Re: Project Name File Number (CU-14-00005) – Applicant Mary Gonzalez

I am responding to your notice of the proposed marijuana producing projects at the proposed site located at 1006 Emerson Road in Kittitas County.

1006 Emerson Rd.

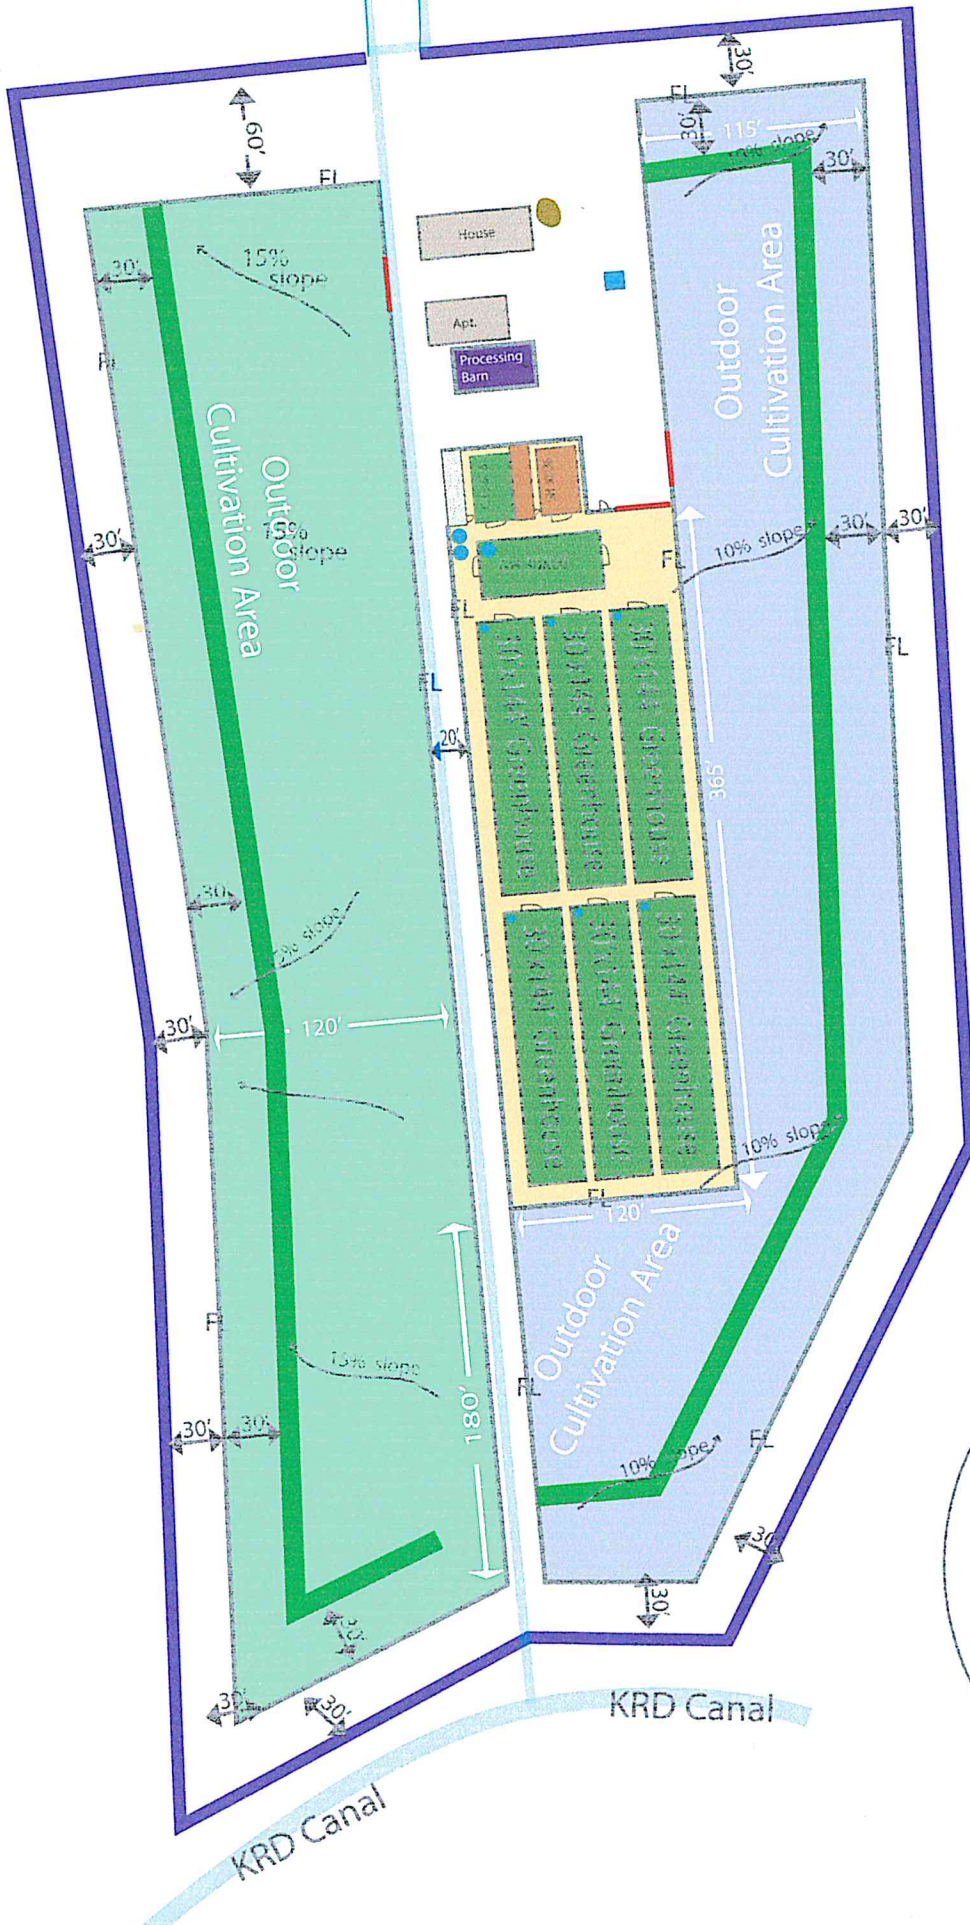
2. VIEWS – The proposed 8 foot high solid metal fence will have a negative impact on rural views. The surrounding area is composed of small and large farms with low / open fencing with isolated small to large residences and associated farm out buildings. The proposed 8 foot high solid security fence (with or without landscaping) will provide a visual barrier that will limit views from adjacent properties while at the same time provide no barrier to their operation from higher elevation properties. This will be particularly objectionable as the operation grows to the full limits of the 15 acre site.

3. LIGHTING -- The operation of the proposed facility indicates all growing will be outdoors. However, other areas of the applicant's application suggest greenhouse lighting will be required in early morning and evening hours. Greenhouse lighting after sunset and before sunrise visible and to adjacent and surrounding higher elevation neighbors is objectionable and out of character for the neighborhood. All grow house lighting should be in totally enclosed in barns or other structures to limit observation during dark hours.

The applicant indicates that all night time security lighting will be pointed downward. The issue is not just the direction of the lighting, it is the amount of lighting. High pole lights or other lighting systems than shed sufficient light for security will by definition result in excessive / objectionable lighting to the surrounding farms and residences. Specific details of the proposed lighting (location and type of lights, number of lights, height of lights, lighting direction, lighting levels at and adjacent to the site, etc.) are necessary to properly review. Please provide.
